DRB Comments

PROJECT # 1008325

APPLICATION # 10-70129

RE: Lots 8 – 10, Block 3, Realty Sales Co. 1st Addition

SUMMARY PLAT
LOT IIB OF BLOCK 3
REALTY SALES COMPANY'S
FIRST ADDITION
BEING A REPLAT OF
LOT IIA
AND A PORTION OF
VACATED 9th STREET
BERNALILLO COUNTY, NEW MEXICO
SEPTEMBER 1982

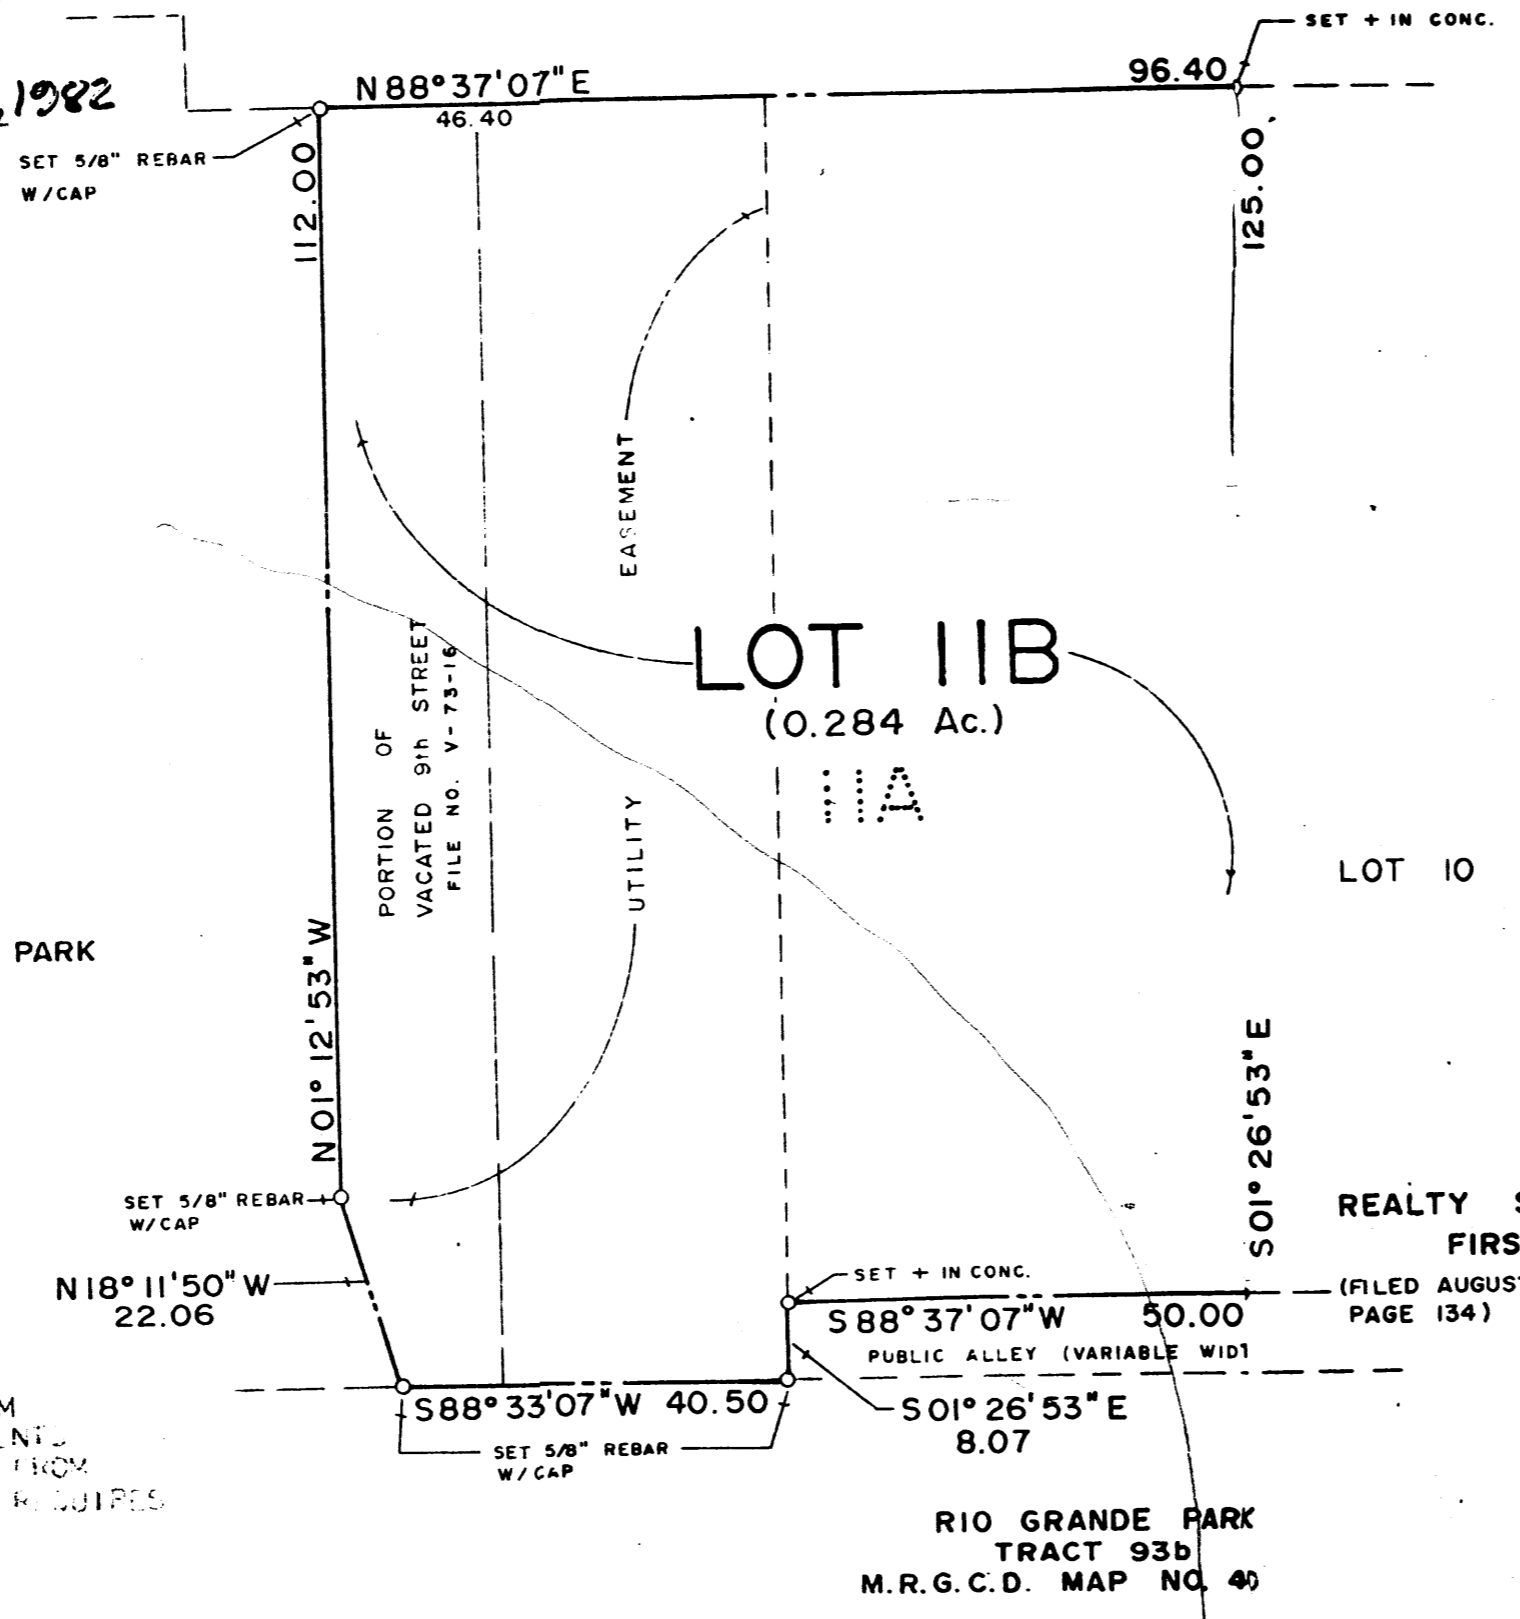
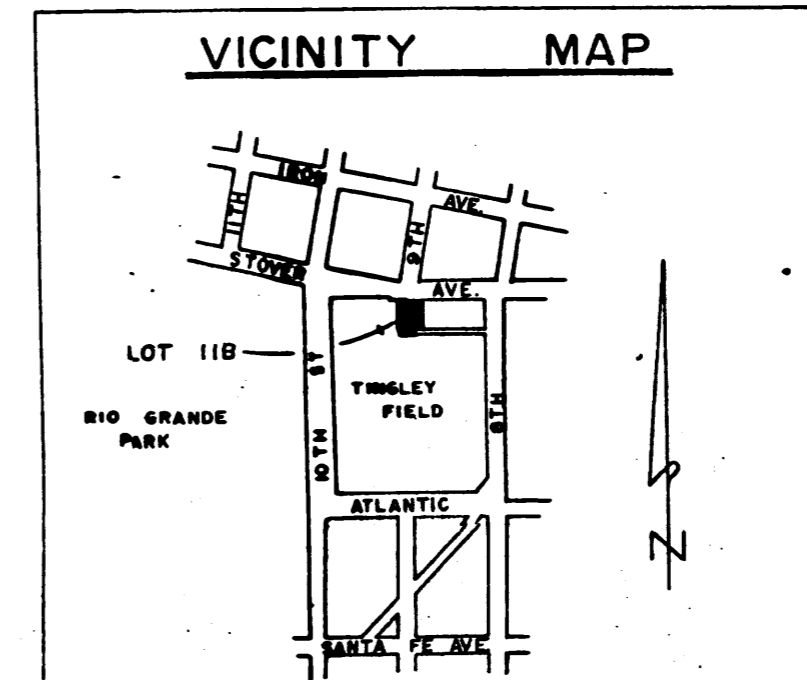
Previous vacation [Vac. Ord. 73-16] vacated 9th Street and the alley to the west (Block 4), which has created a dead-end alley adjacent to Block 3. However, it appears Tingley Park improvements have been constructed within the alley right-of-way in Block 3 adjacent to Lot 11B (owned by the City, and also developed as part of the park).

Typically under the current Subdivision Ordinance, all of an alley must be vacated, not just portions of an alley adjacent to a few lots; however, in this situation there may be a net benefit to the public welfare by decreasing the length of the public alley. If approved, the City may be able to designate the western remainder of the alley as "non-right of way" for the City as owner of Tract 11B.
